Comments on the Applicant's Responses to Deadline 4 Submissions [part 11 – Response to Mr Moore and Dr Moore]

Unique Reference Number: 20040614

In their Section 2, which actually does relate to me, Tritax have responded to my document "Response to the Examining Authority's Written Questions and Request for Information ExQ1 Question 1.8.18 regarding the Applicant's methodology for noise assessment in the proposed Hinckley National Rail freight Interchange." of the 9th January 2024 (Deadline 4).

ES Appendix 10.10 Summary Results

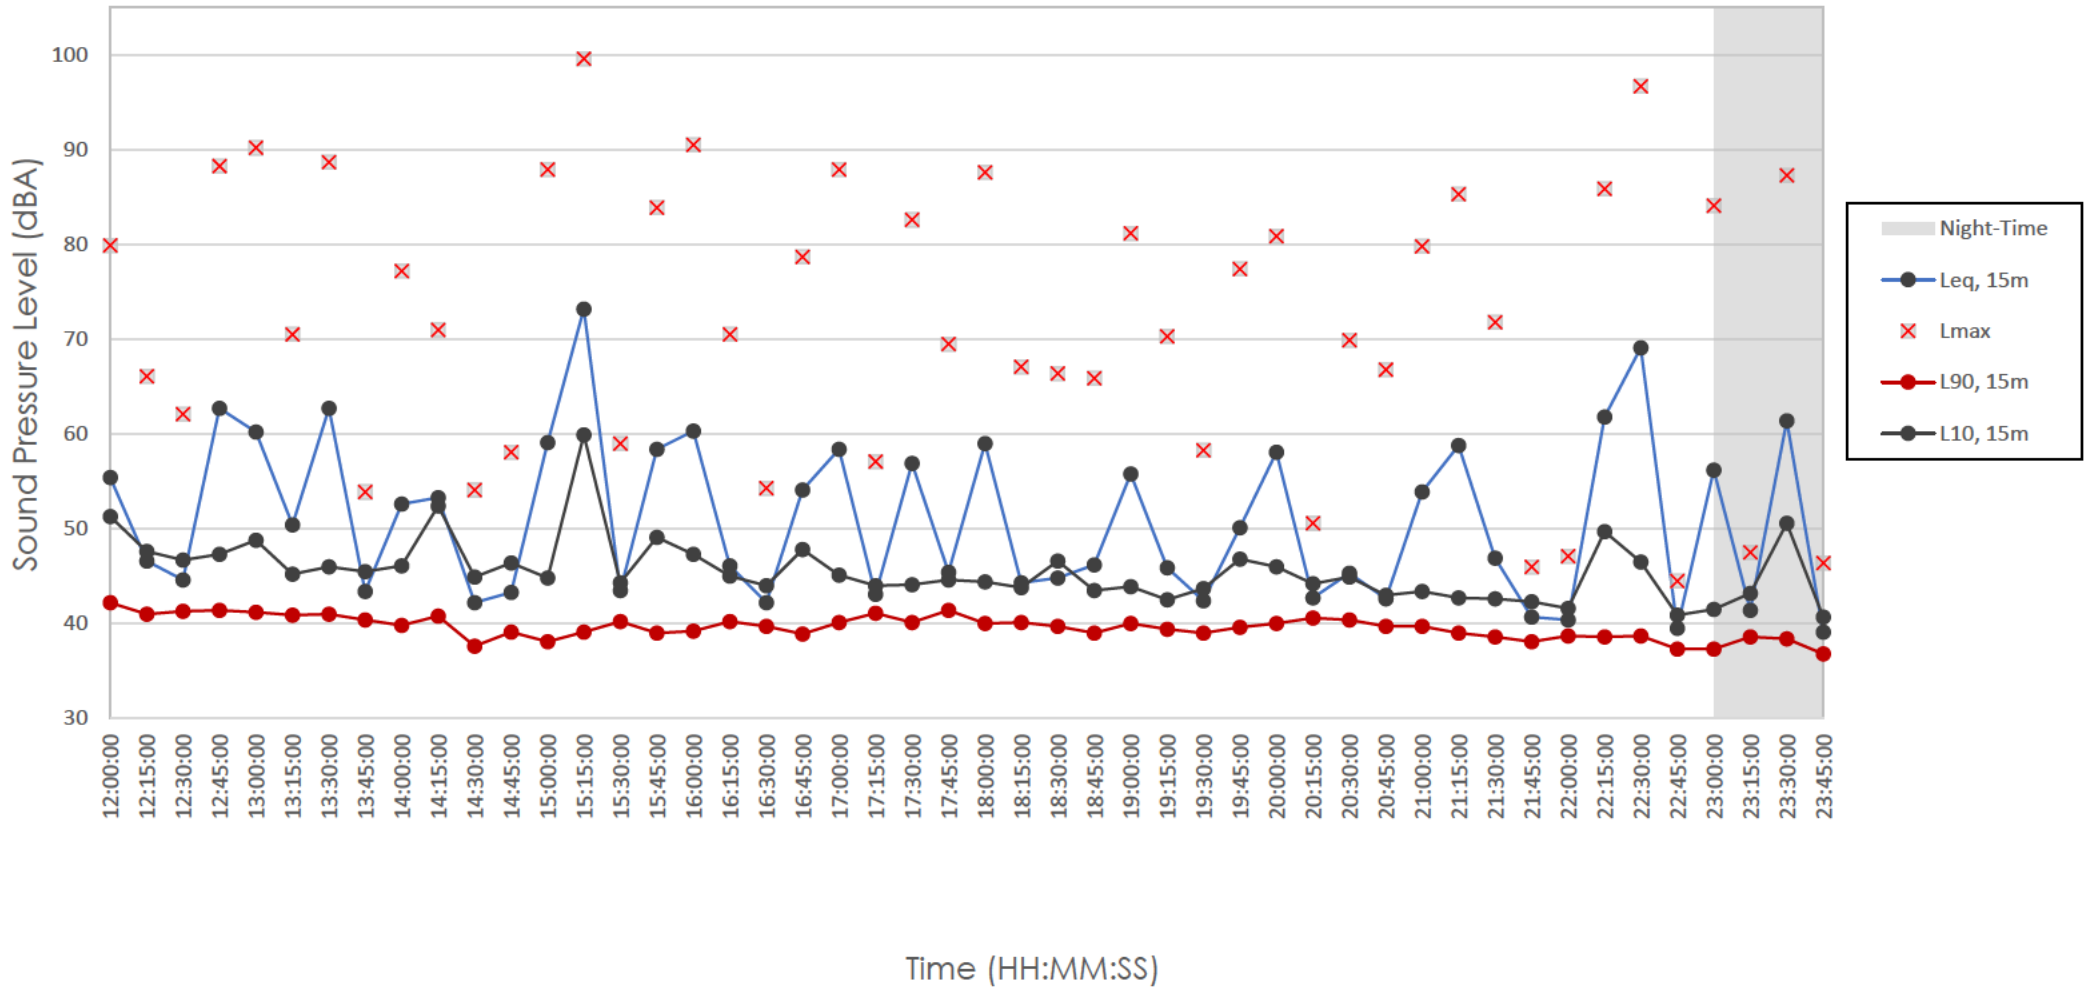
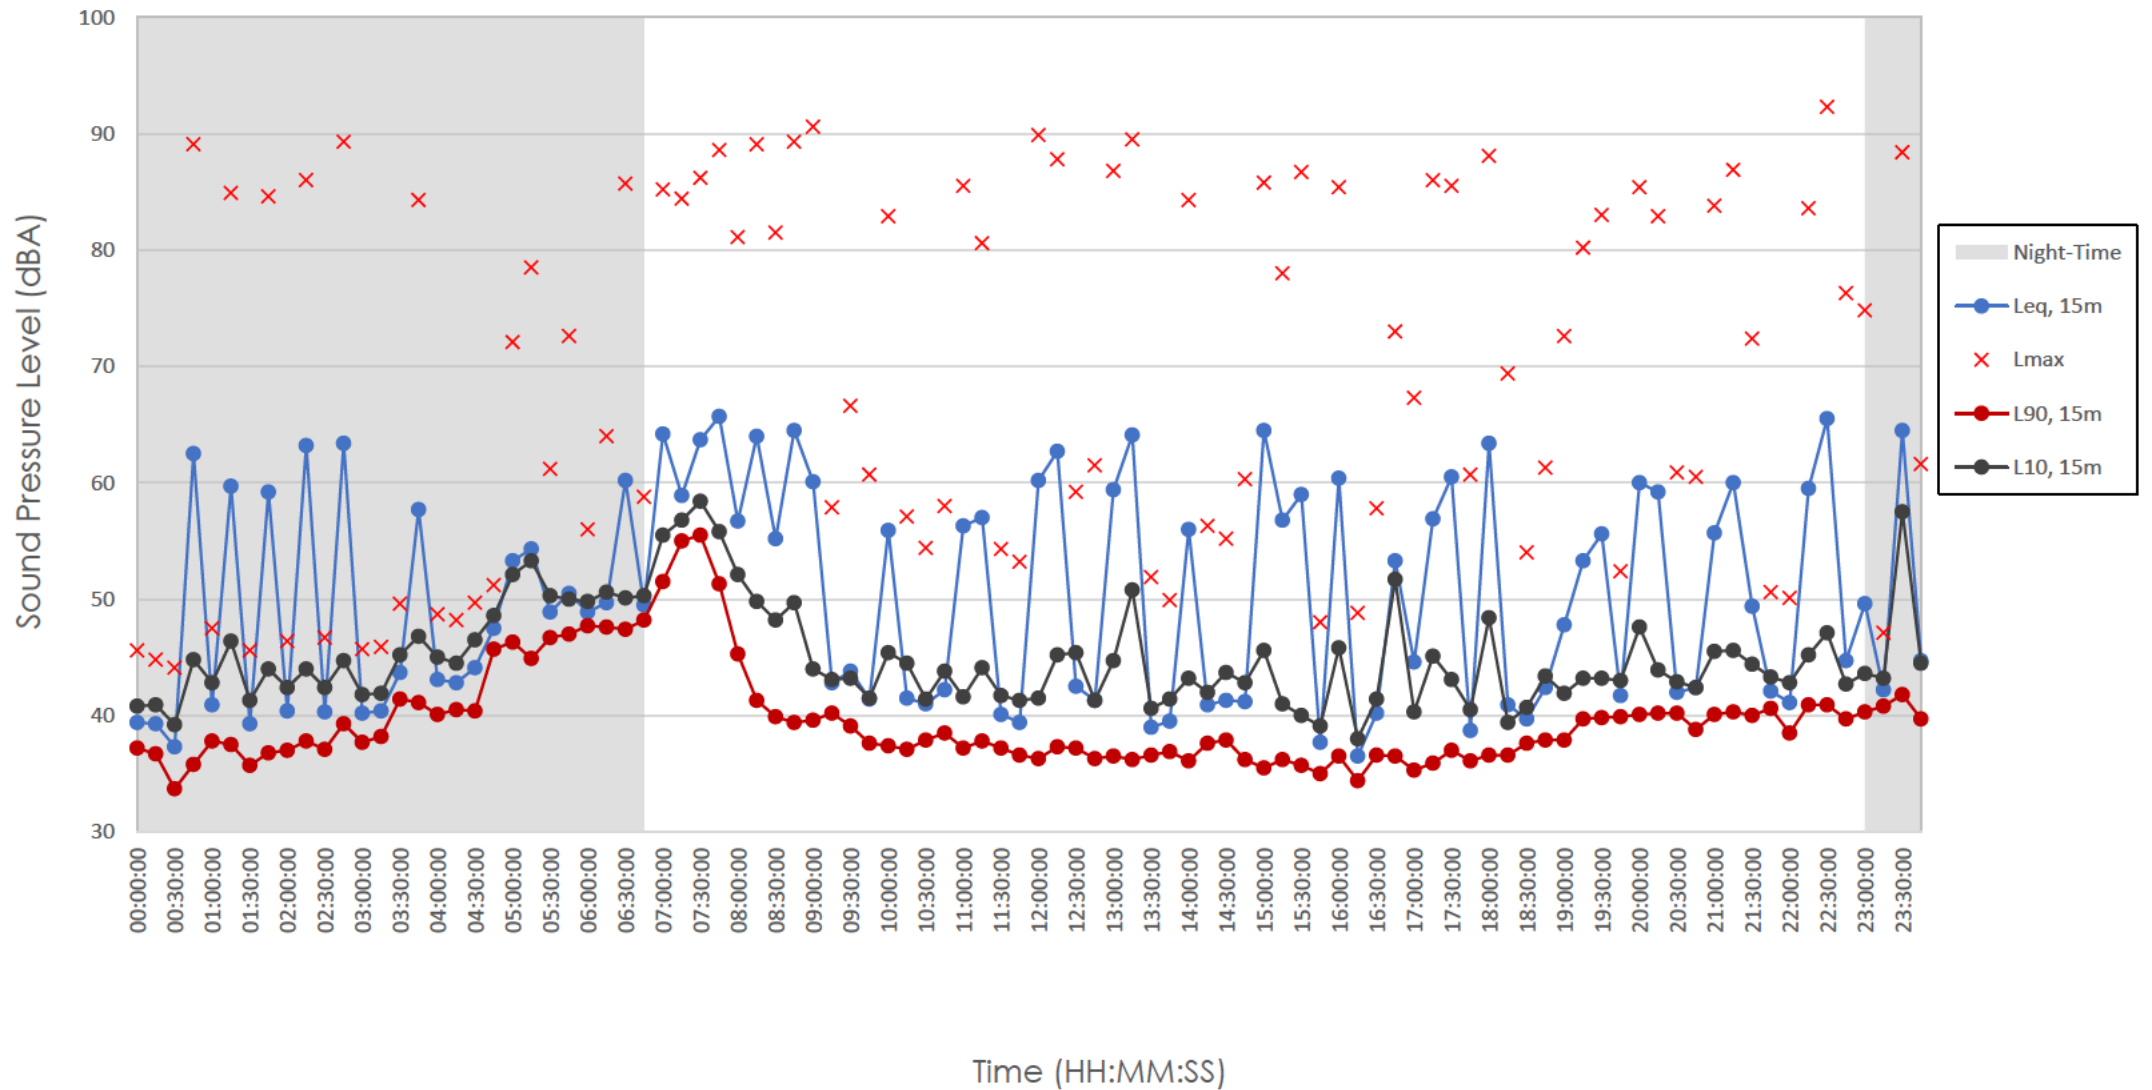
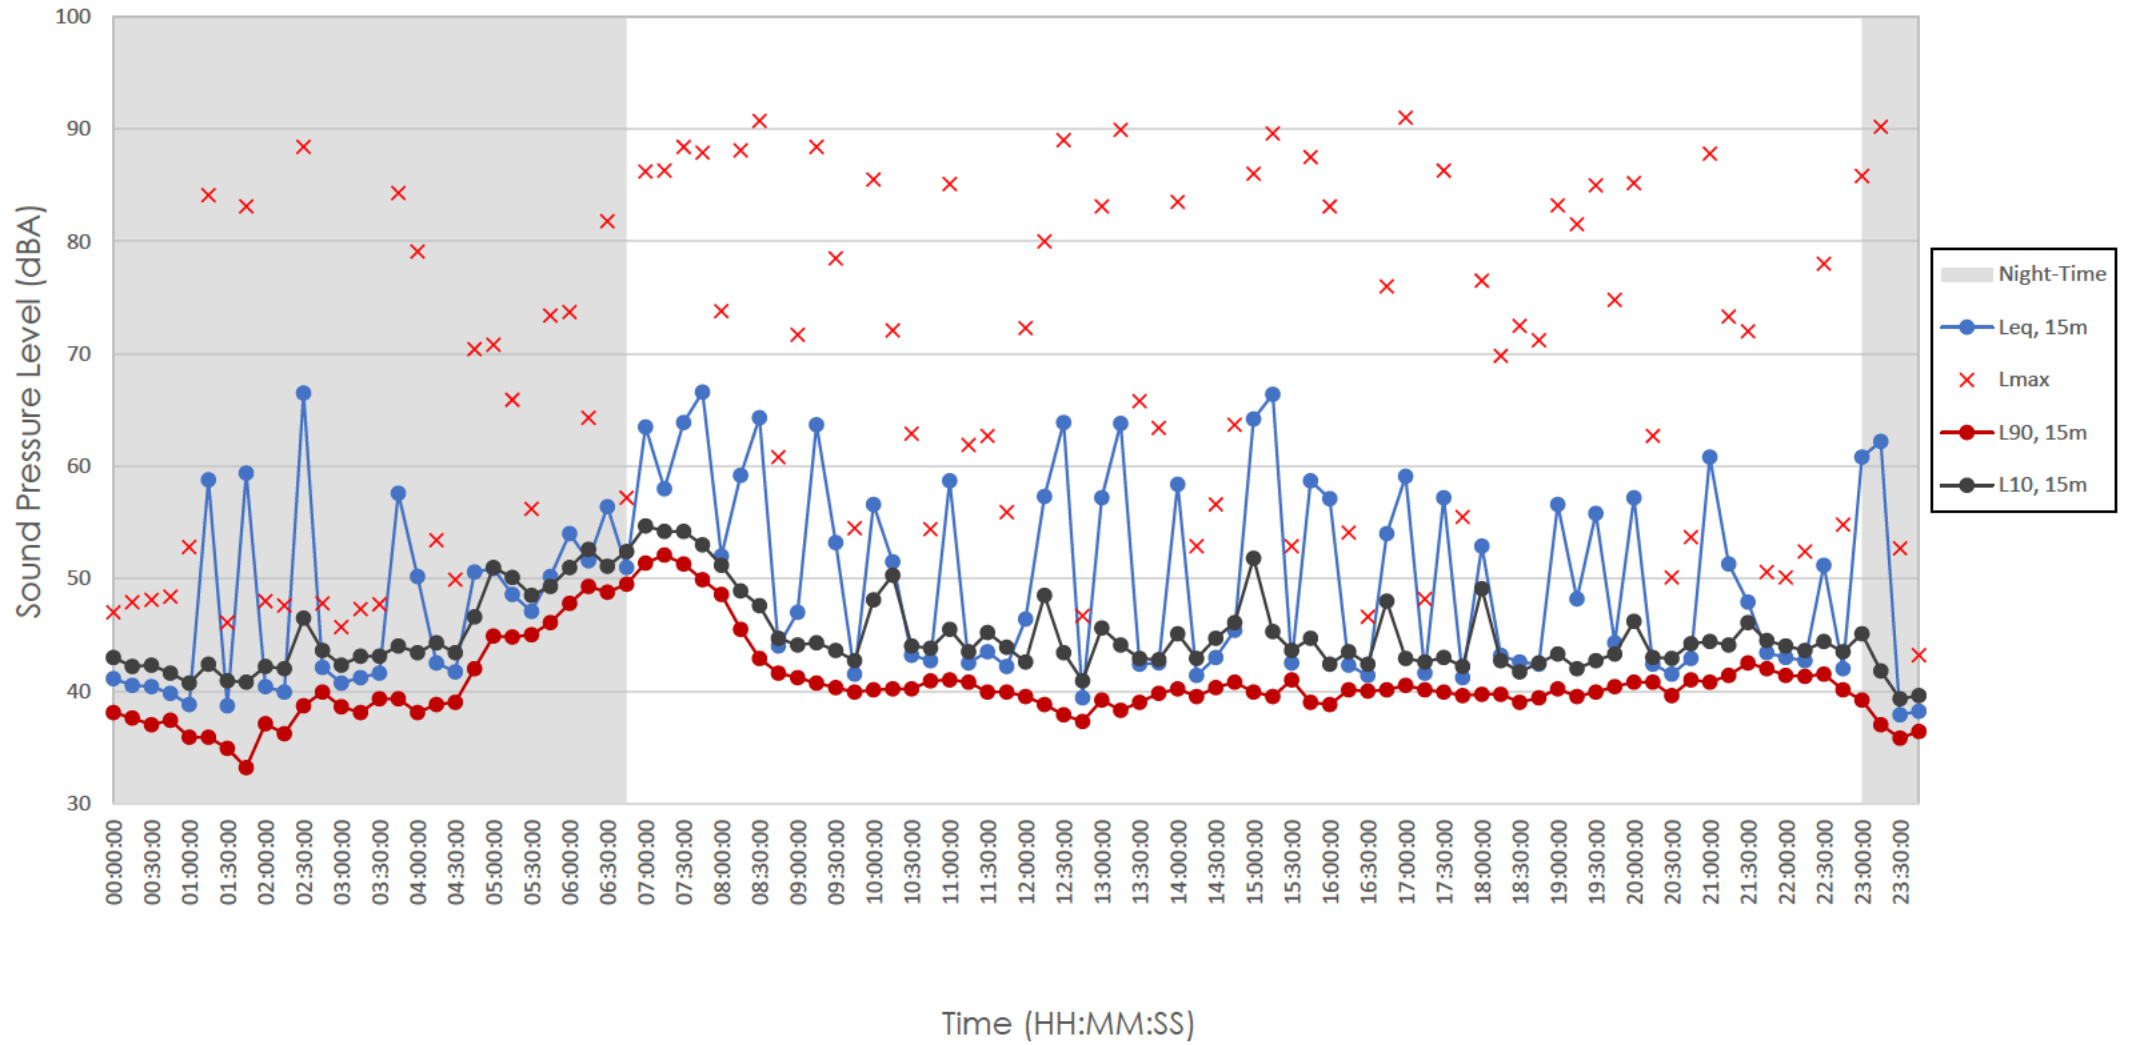
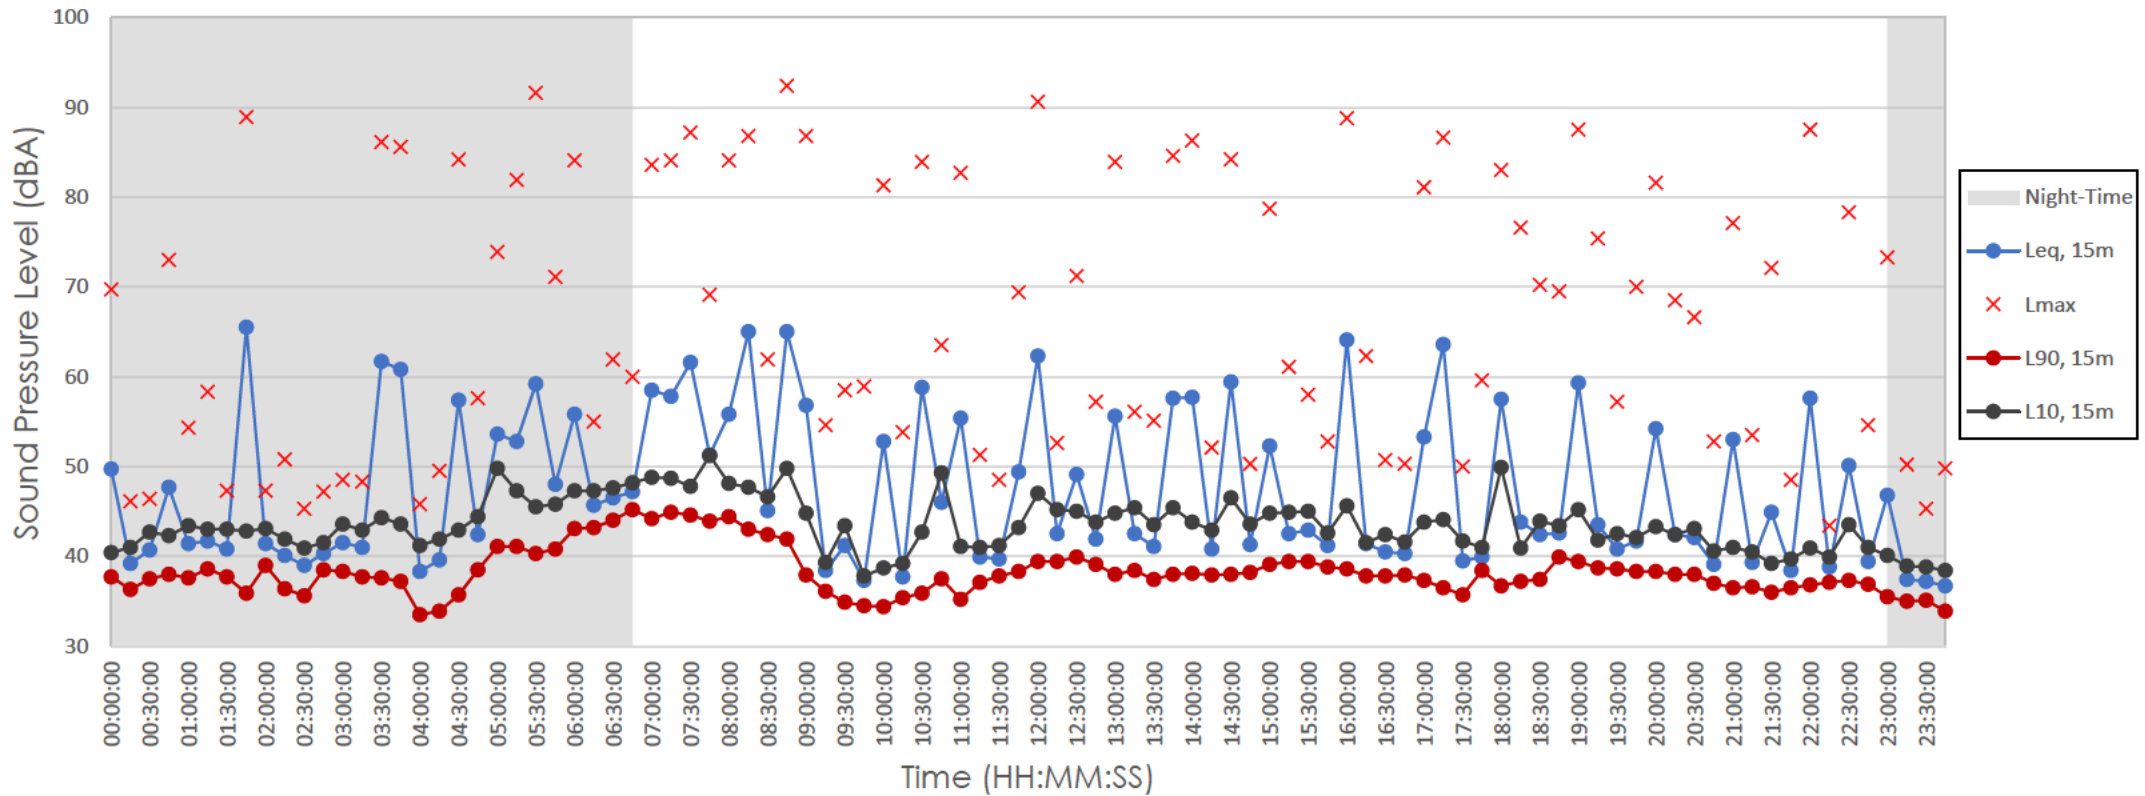
Moreover, the noise levels Tritax measured at the trackside and indicated in graphical form in Tritax’s ES Appendix 10.10 “Summary Results” are entirely in line with the train passby characteristics that I have indicated.

Tritax’s statement is incorrect, as I shall explain. The noise levels measured at the trackside over the 7-day period are continuous along the length of the line that is considered here, **and no rail noise maps are required**. Further, the DEFRA rail noise maps that Tritax have sought to introduce are intended for use only at a strategic level and are very much higher (12dB to 15dB) than the noise levels that Tritax measured at the trackside at NMP3 and NMP4 over the 7-day period and then used as a foundation of their Noise and vibration report.

Moreover, the DEFRA rail noise maps give no indication of the noise levels at Weekend daytimes or Weekend night-times, and indeed are so broad-brush that they indicate a **higher** rail noise level at night-time than daytime. In contrast, the noise levels Tritax measured at the trackside over the 7-day period give detailed information for both Weekends and Weekdays, and both daytime and night-time.
